ENG-PPR19042-R2-SDP-Redlines Summary_Markup Summary

ENG-PPR19042-R2-CD-GEC-Redlines Summary_Markup Summary

ENG-PPR19042-R2-O&M-Redlines Summary_Markup Summary

NOVEMBER 2019 **LEGEND**

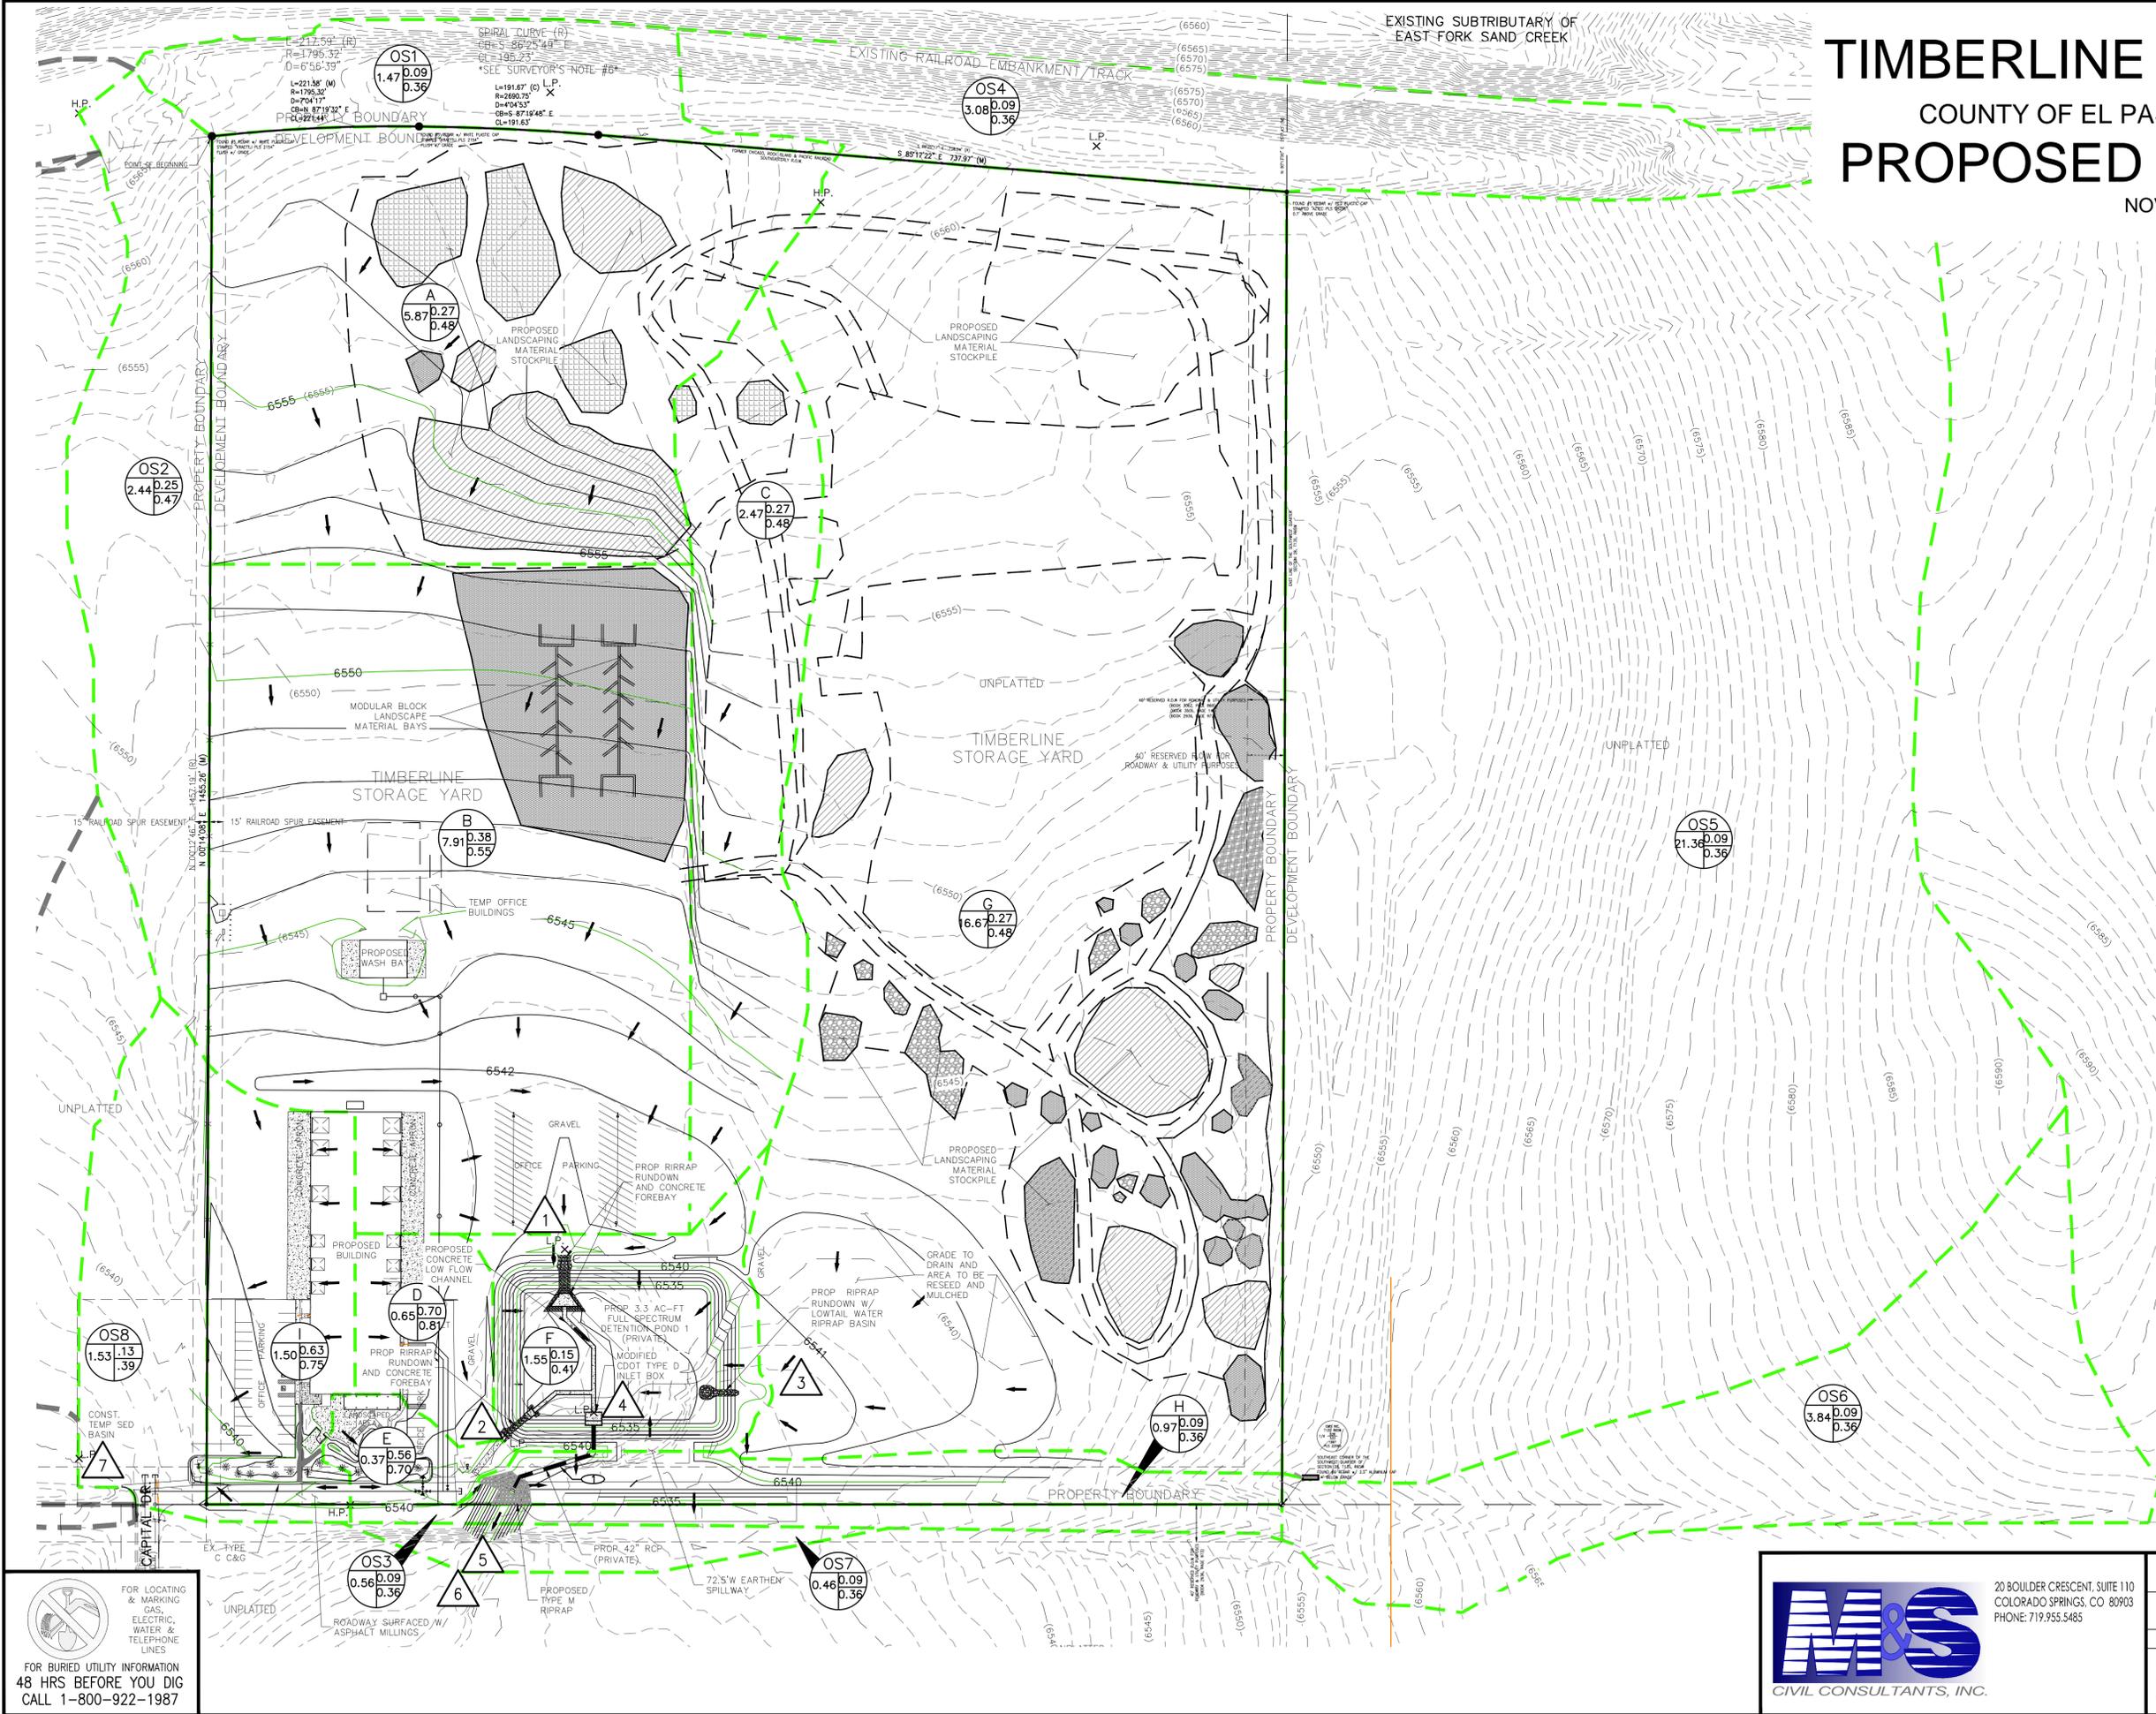
Subject: Arrow
Page Index: 82
Date: 12/17/2019 10:53:24 PM
Author: dsdrice
Color: ■
Layer:
Space:
Page Label: [1] PROPOSED DRAINAGE MAP

GRADING AND EROSION CONTROL PLAN

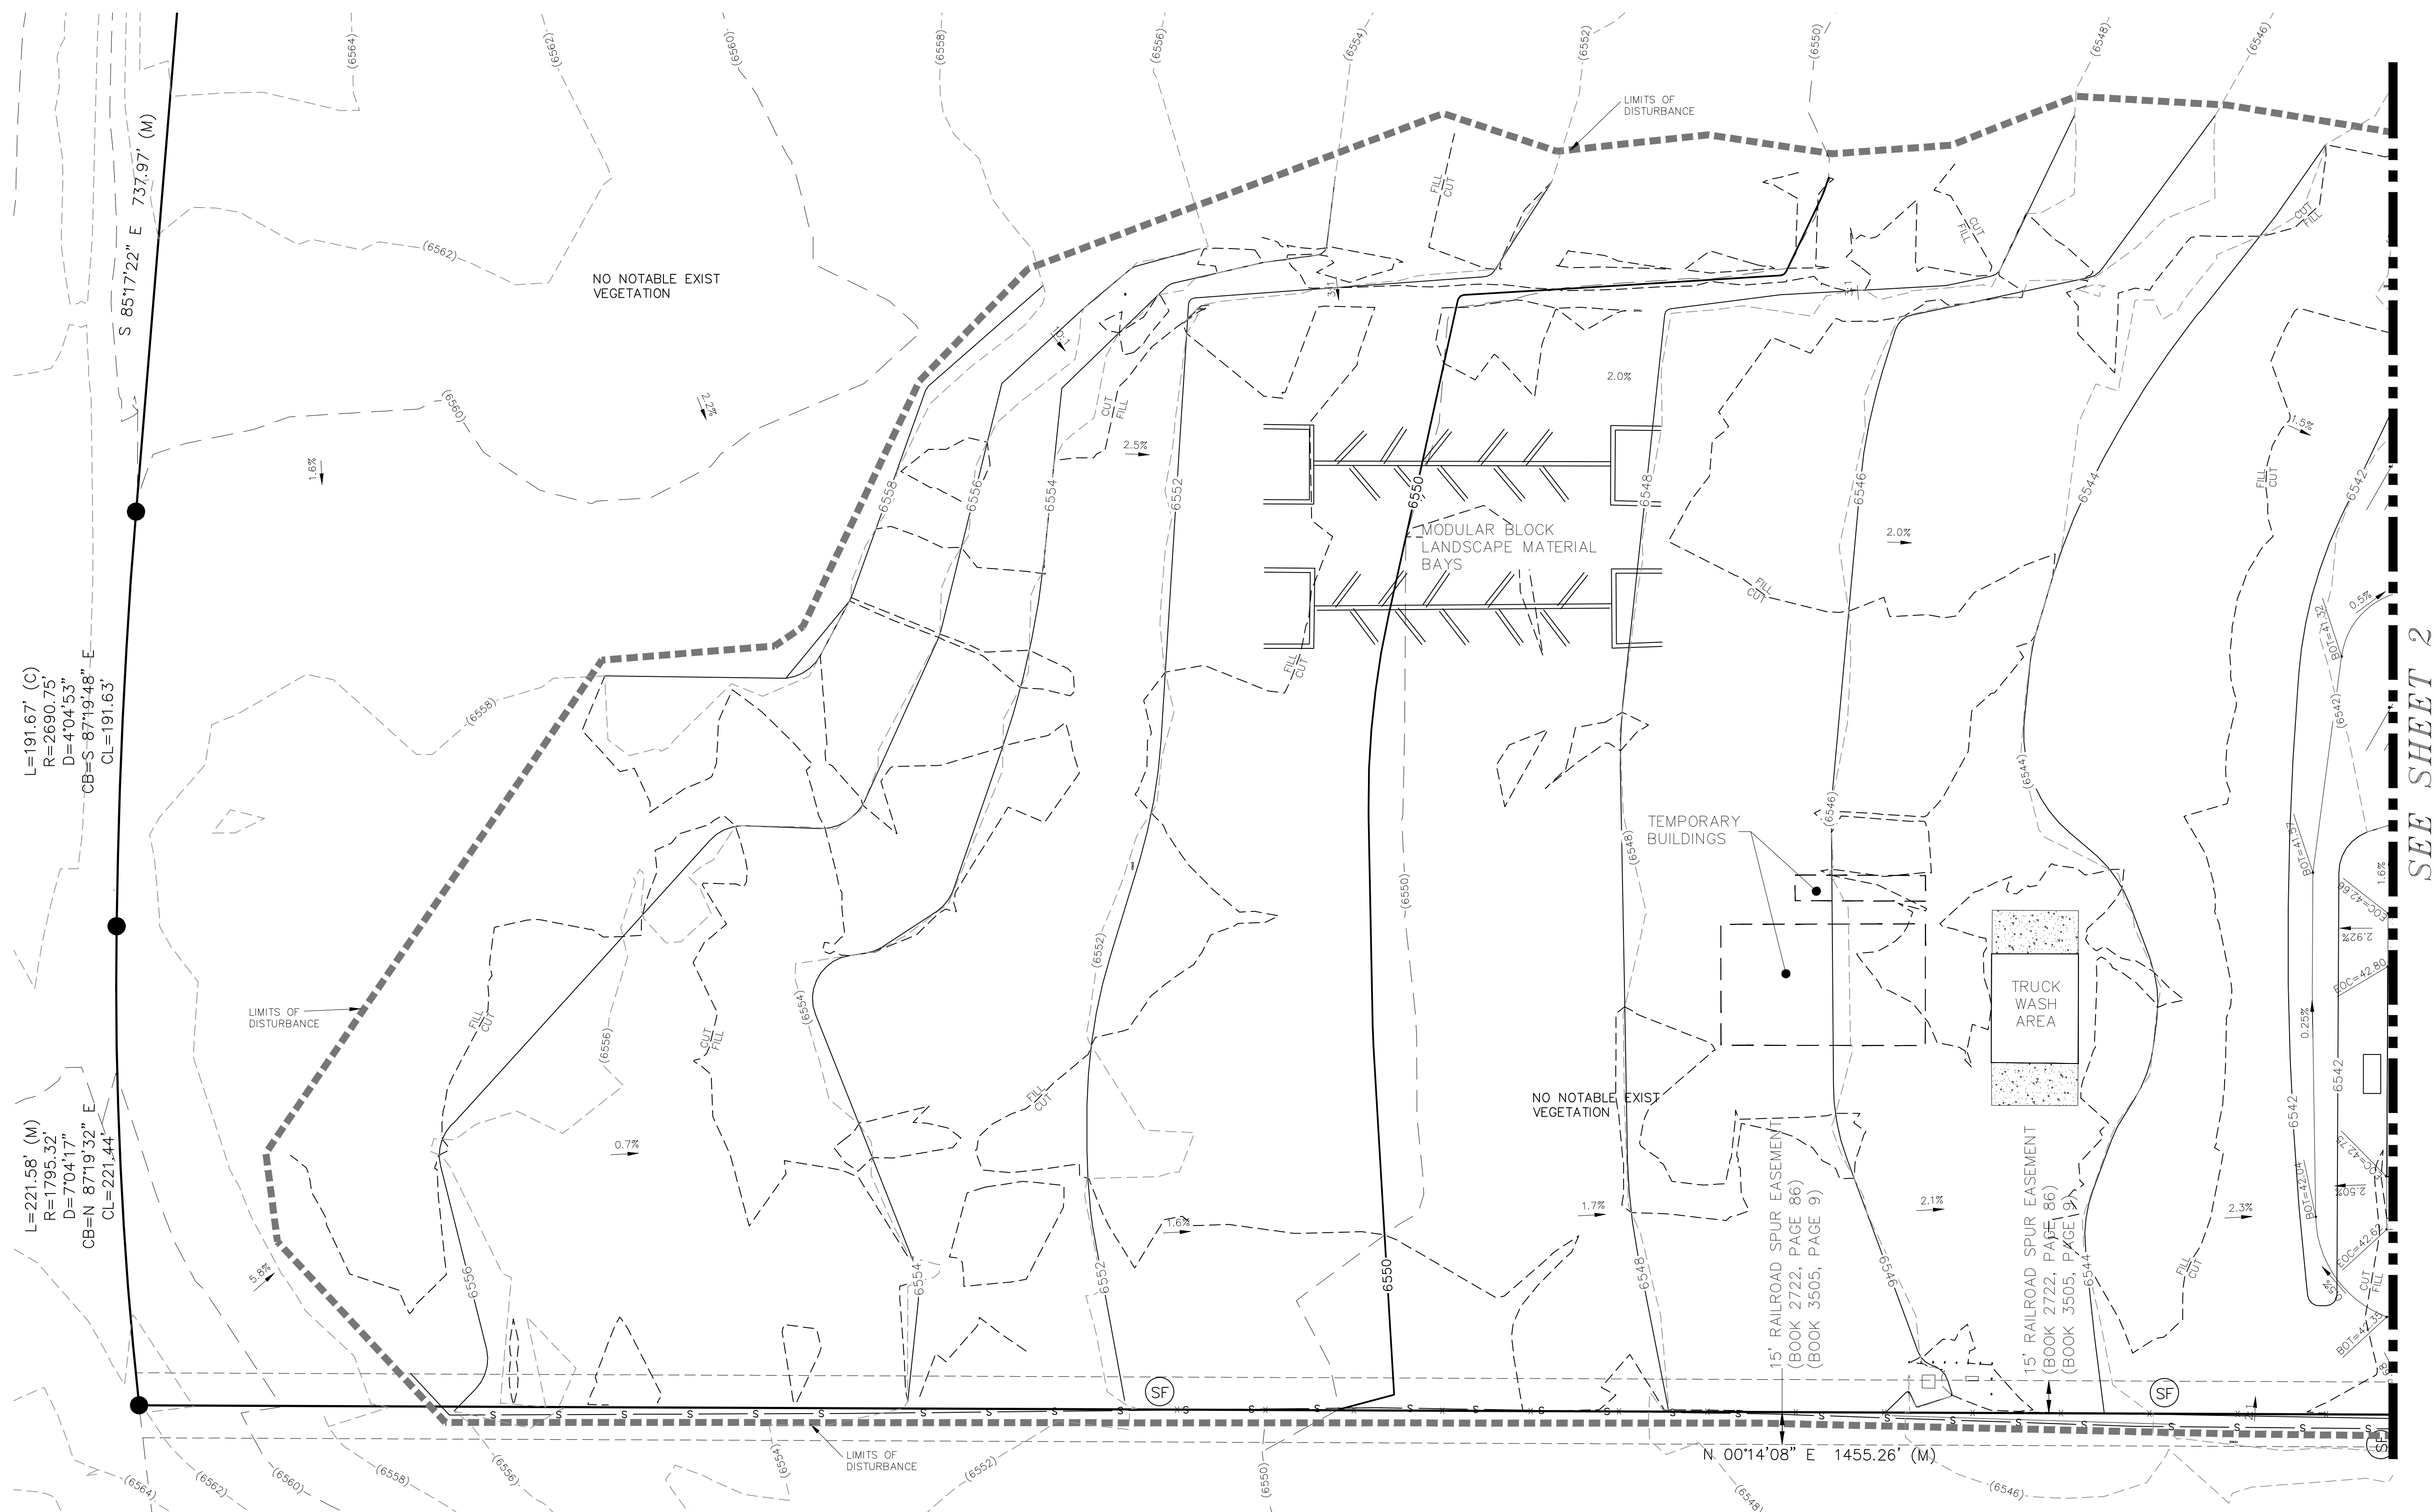
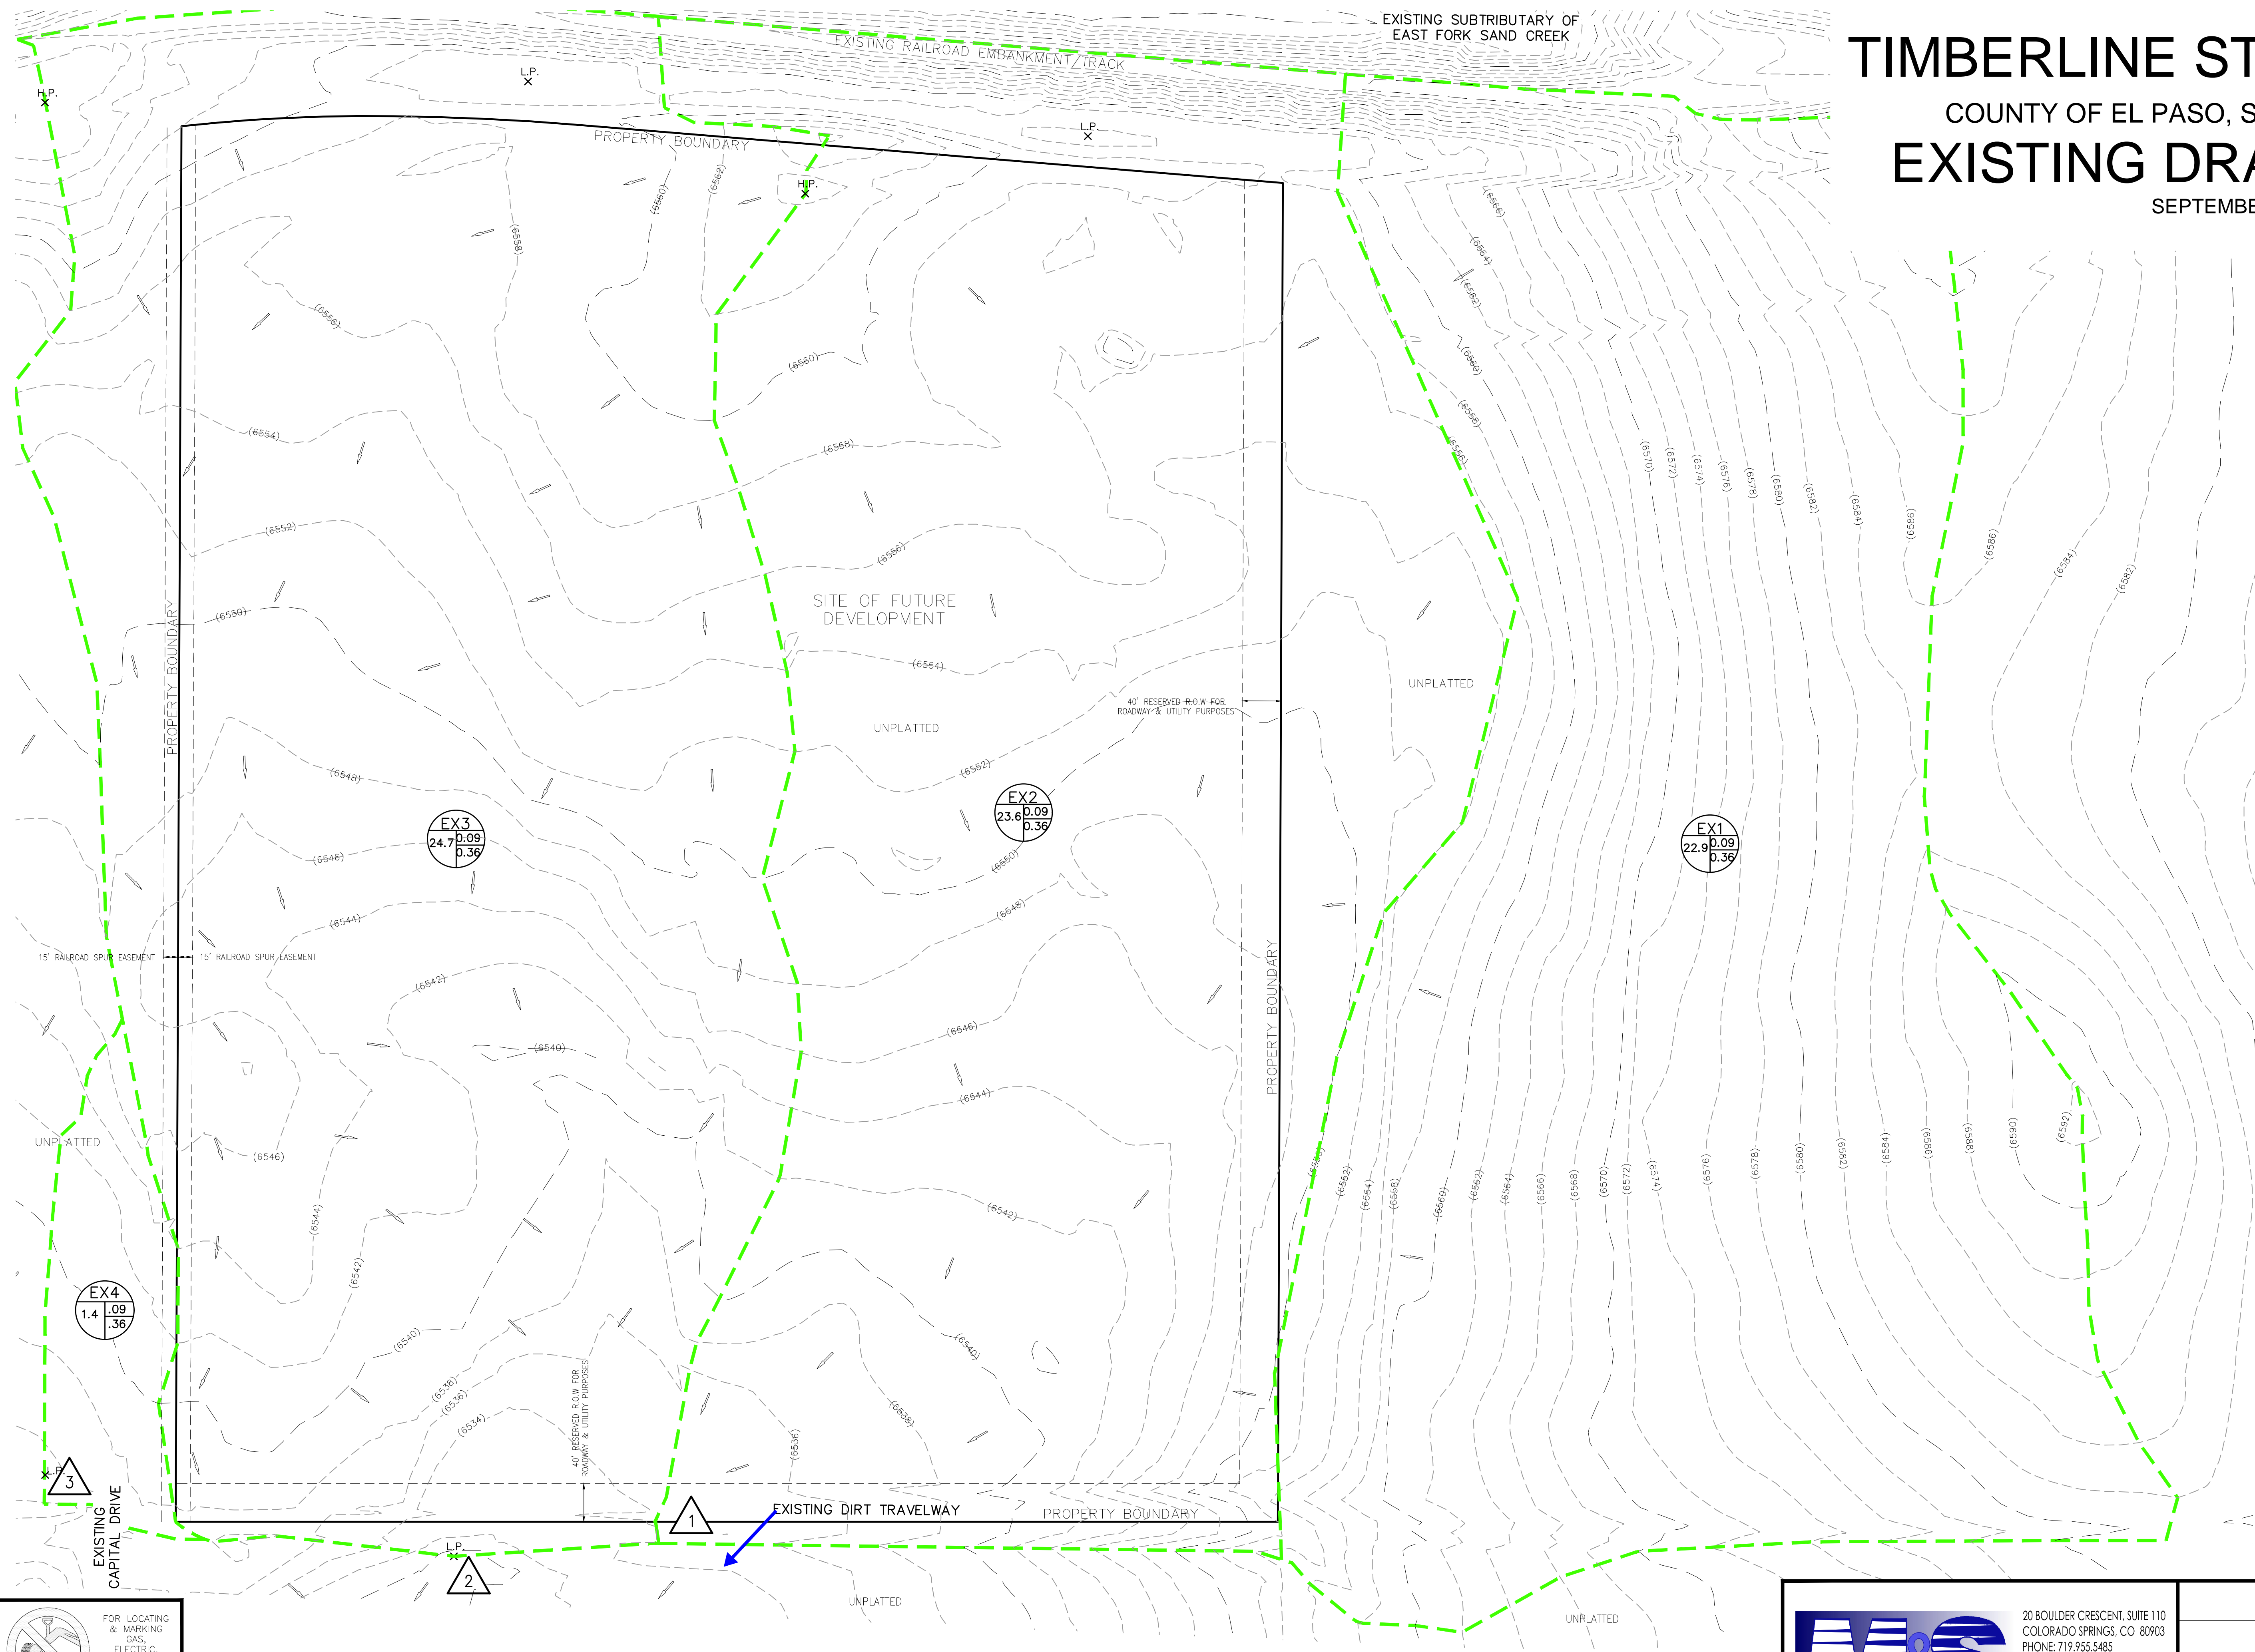
Adjust silt fence to follow contours

Limits of disturbance around pond? Label and show all offsite grading.

adjust silt fence for proper use

BMPs?
